Application No: EP/7/21/HH
Site Address: Little Dormers 23 Upper Drive East Preston BN16 1QN
Description of works: New bay/porch skirt roof to front elevation & single storey front extension to provide additional garaging.

Thank you for your internet representation made on 2nd February 2021 which has been recorded as an objection with the comments as follows:

Drawing Name
Elevations-Proposed

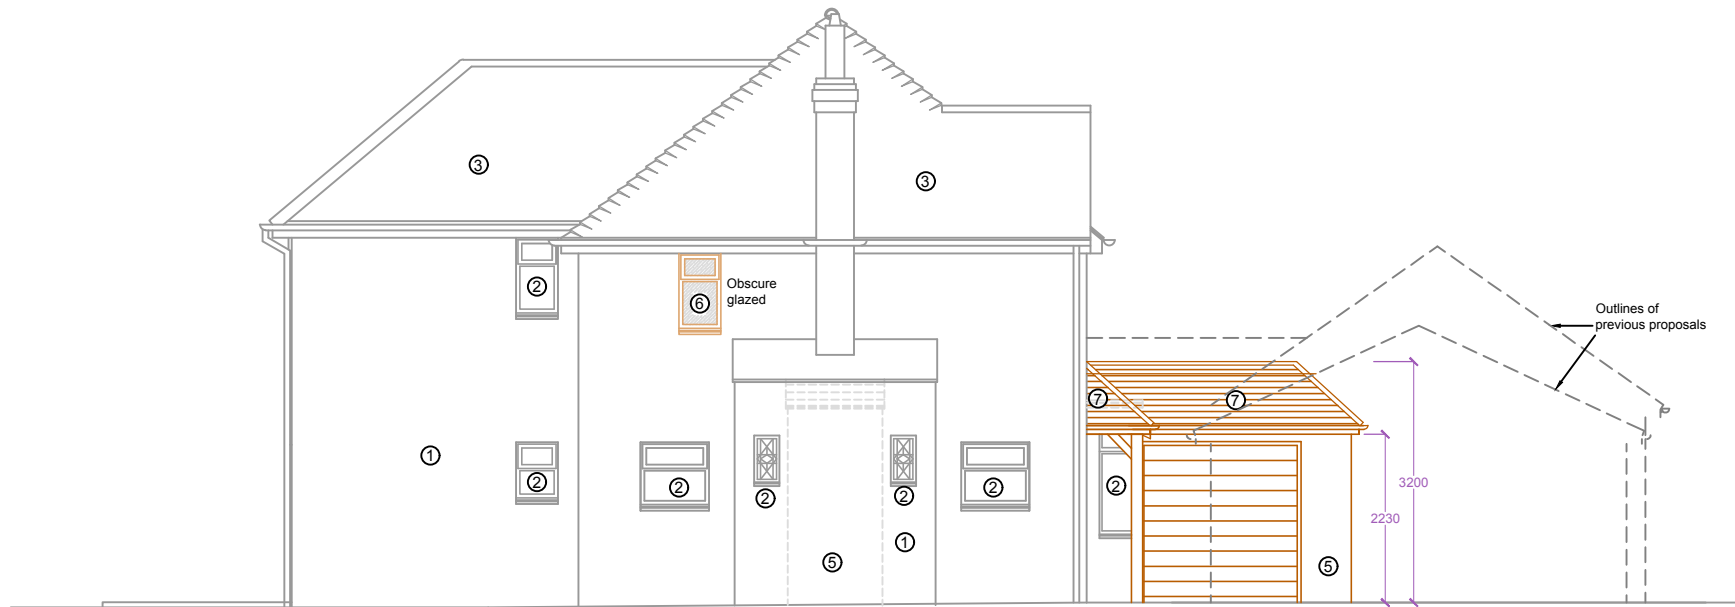
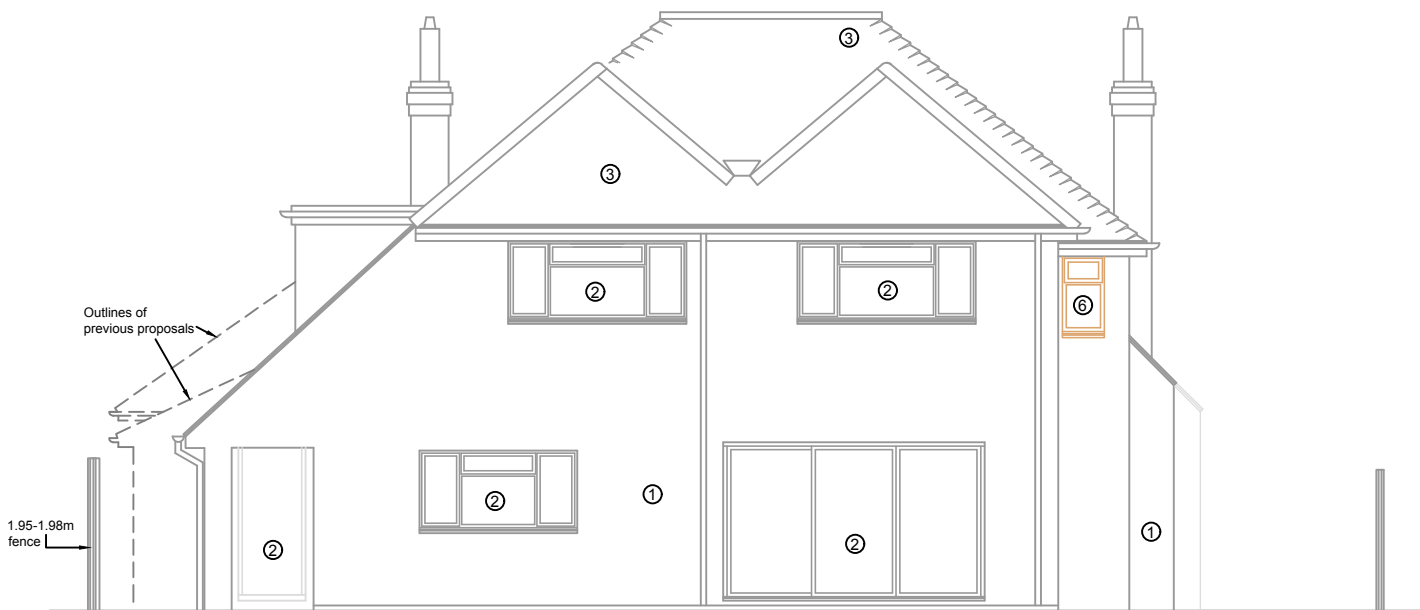
We object to our loss of privacy by openings on their side elevation overlooking our garden and bedroom windows
